Project #: 1009886 *Application #:* 13DRB-70745

Project Name: MRGCD MAP # 40

****Your request was approved on 11-21-13 by the DRB with delegation of signature(s) to the following departments - outstanding comments to be addressed****

PLAT OF
LOTS 1 & 2
LANDS OF ABENICIO GALLEGOS
 BEING A REPLAT OF TRACT 68, 82-A-2, 82-A-1-A & 82-A-1-B
 M.R.G.C.D. MAP NO. 40
 PROJECTED SECTION 20, T 10 N, R 3 E, NMPM, TOWN OF ALBUQUERQUE GRANT
 CITY OF ALBUQUERQUE, BERNALILLO COUNTY, NEW MEXICO
 NOVEMBER, 2013

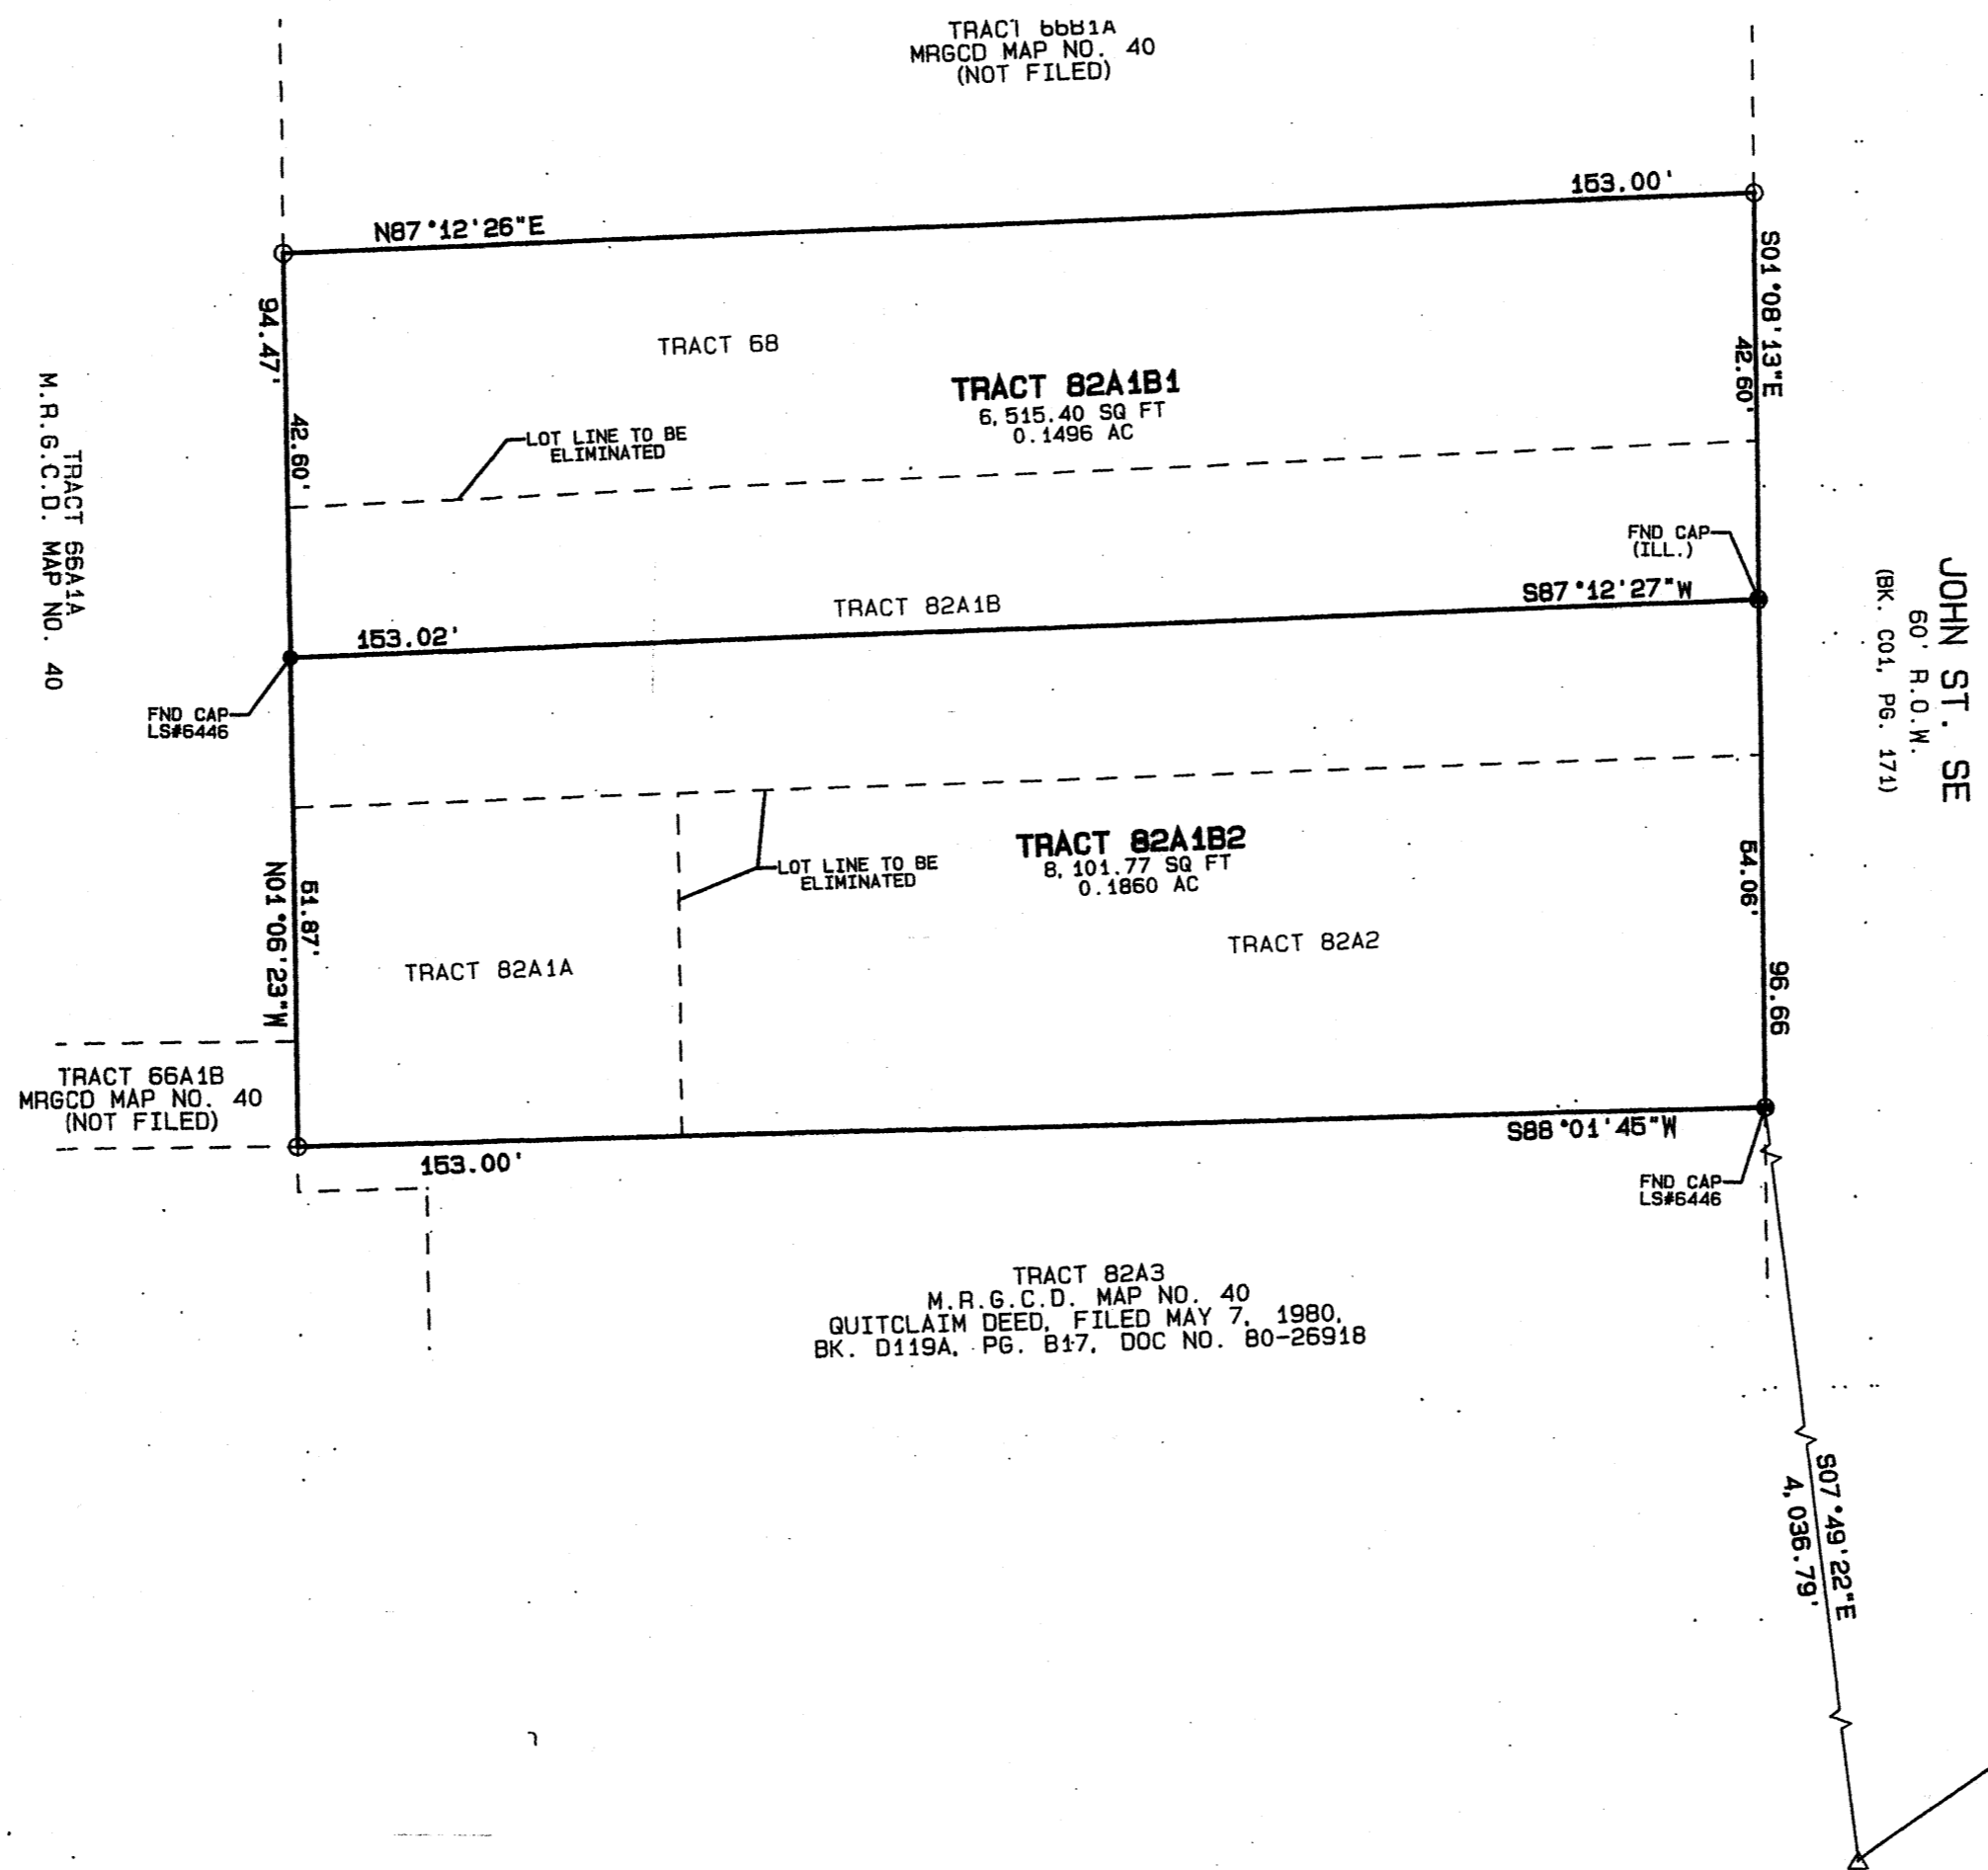
PLANNING (Last to sign): • revise Note 11 8-16-12
• delete Note 12
• verify signatures
